From: Nia Russell [REDACTED]
Sent: 23 October 2017 11:52
To: Michael Eastham
Cc: Arfon Hughes
Subject: Fwd: Saltbox, Bognor Regis - Heads of Terms

From: karen jenkins [REDACTED]
Subject: RE: Saltbox, Bognor Regis - Heads of Terms
Date: 23 October 2017 at 11:04:11 BST
To: Arfon Hughes [REDACTED]
Cc: Nia Russell [REDACTED] Reg Kirk [REDACTED]

In Nia's absence, there are just two design details that have arisen regarding the Unit 2 Warehouse:

REFER TO SHEETS 4 & 5 FOR CONTINUATION

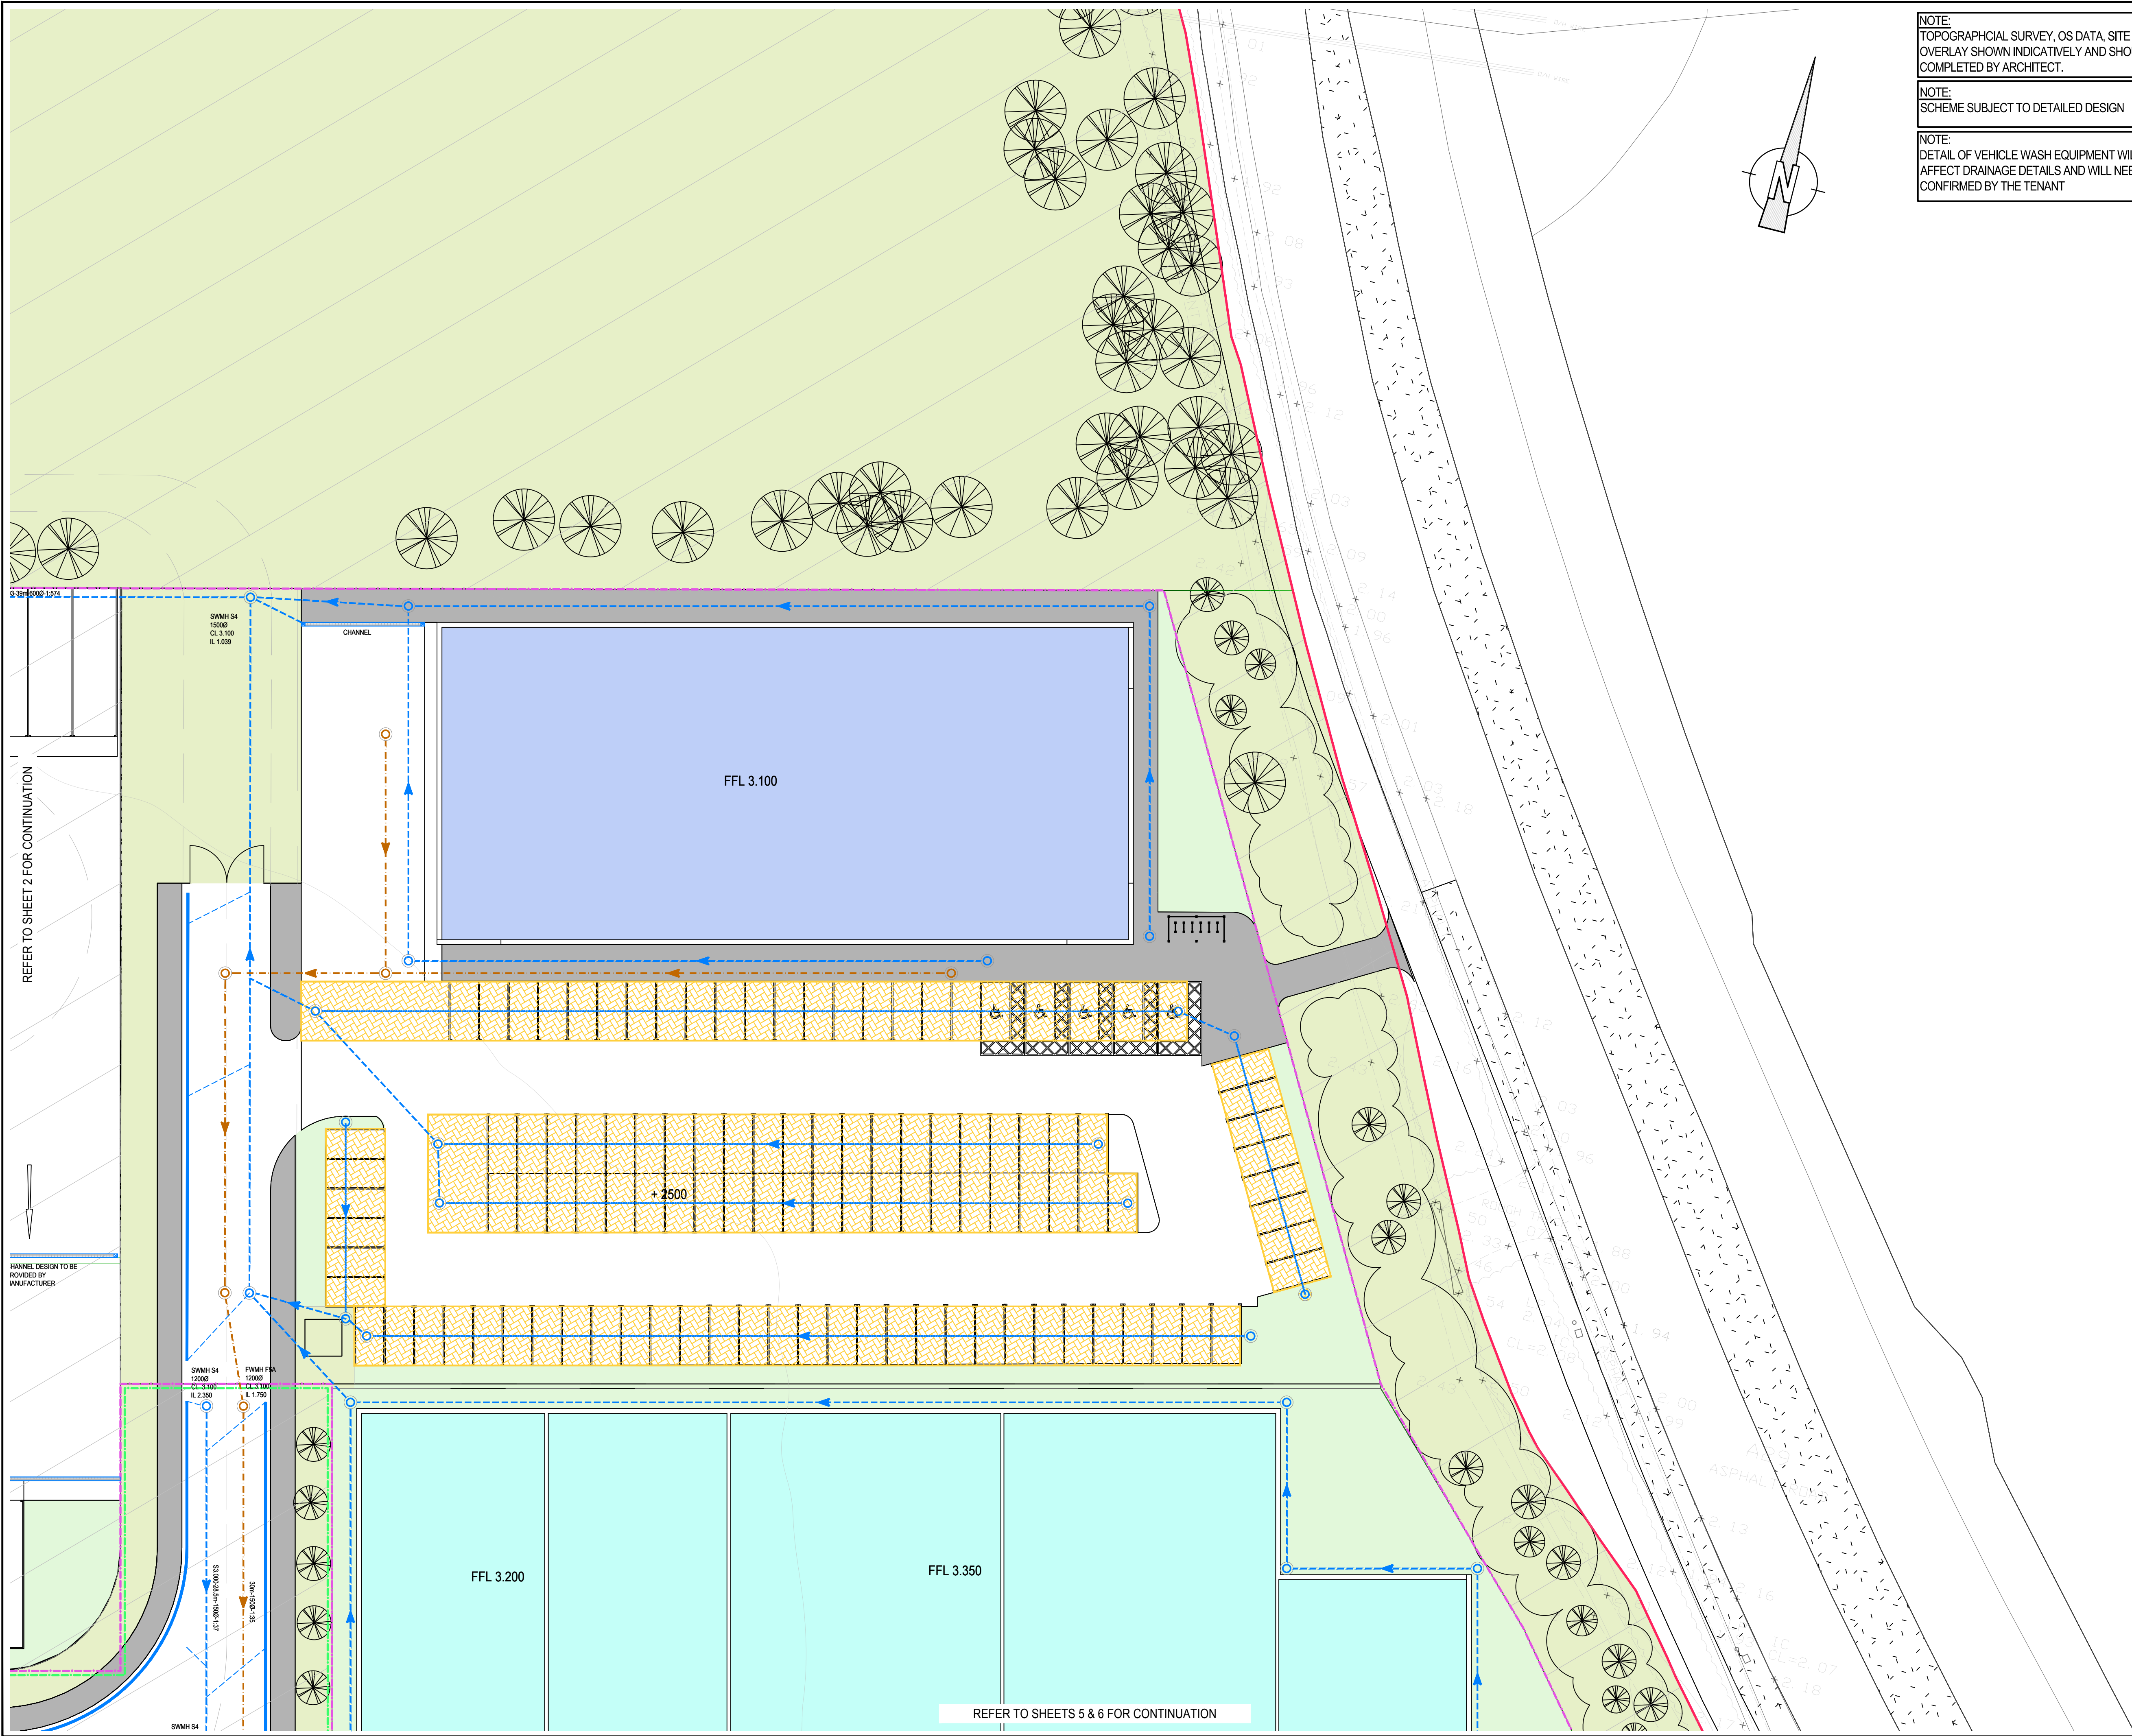
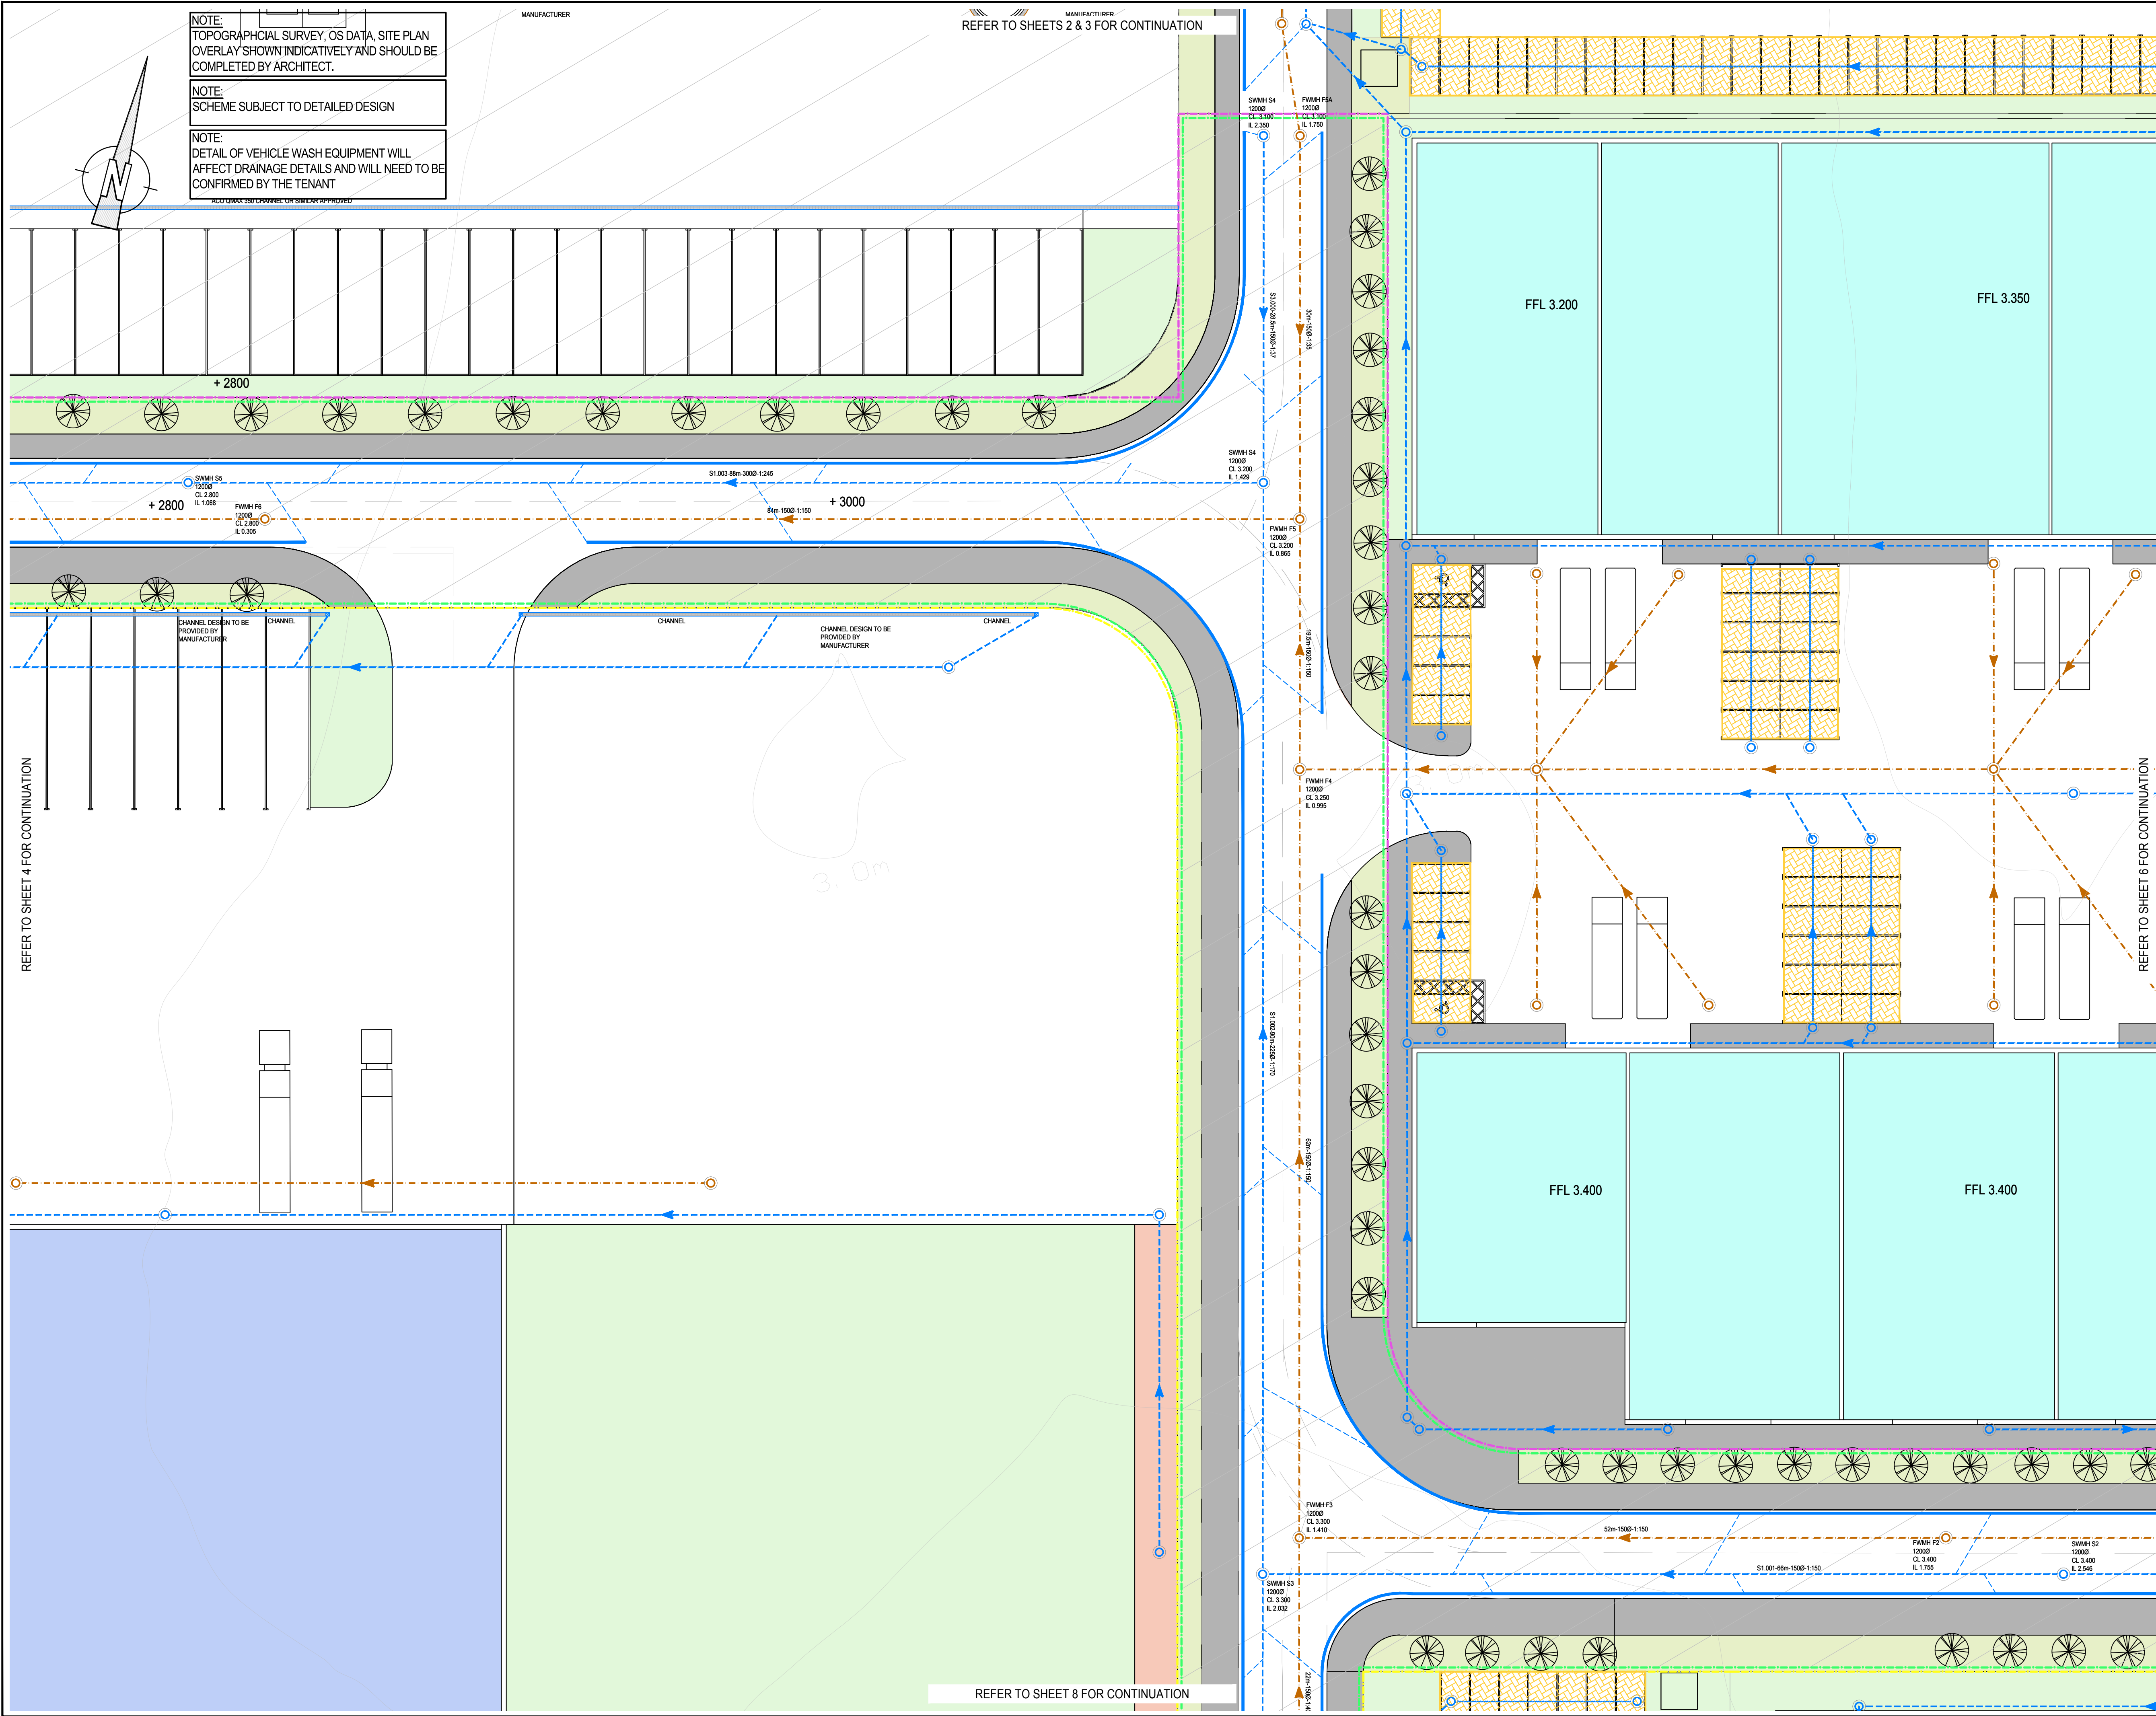
- 3) The Environment Agency normally discourages the use of on-site water treatment plants. Do you need an on-site water treatment plant?

For the Saltbox parcel (which forms part of the Bognor Enterprise Zone), Southern Water, as the local water authority, were contacted and confirmed that there is currently no means of disposal for the foul water at the site, and the local sewerage infrastructure does not have capacity to take the proposed foul water flows from site. If a site has no means of drainage to an existing public sewer due to third party land, the developer can formally request a new public sewer. This means that the water authority can provide a foul water sewer to serve the site.

A S98 solution was been prepared by Southern Water in May 2015 for the site, that indicates costs associated with a pumped system. Based on the information within the report, 674m of a 2m deep rising main and assuming £1000/m construction cost. The works are therefore valued at CRICA £700,000 which is to be paid by the developer. Based on this value, it is not financially viable for the development to progress with the Section 98 Application. In addition, based on other similar schemes, it is estimated that the S98 design process will take between 52-78 weeks before works can start on site.

Initially, a 3 stage wastewater system is proposed for the Saltbox site to deal with the foul water flows. The sewage is first settled to remove the solids and then biologically treated in an aerated biozone, consisting of rotating discs, or air injection, with a final settlement stage to remove the fine solids. The effluent is discharged, on average, 95% clean, to a land drainage system, then finally the watercourse, (subject to Local Authority and Environment Agency Consents).

The treatment system must meet the relevant British Standard at the time of installation. The standards currently in force for new systems are BS EN 12566. The clean treated discharge is subject to Environment Agency 'Consent to Discharge', prior to any flows being discharged directly the watercourse.

It is anticipated that the foul water treatment plant will be overall more financially viable for the scheme, although the final costs are still TBC. In relation to the programme, it is expected will take less time to implement. Hence, is the preferred option for the disposal of foul water sewerage from the proposed Saltbox site.
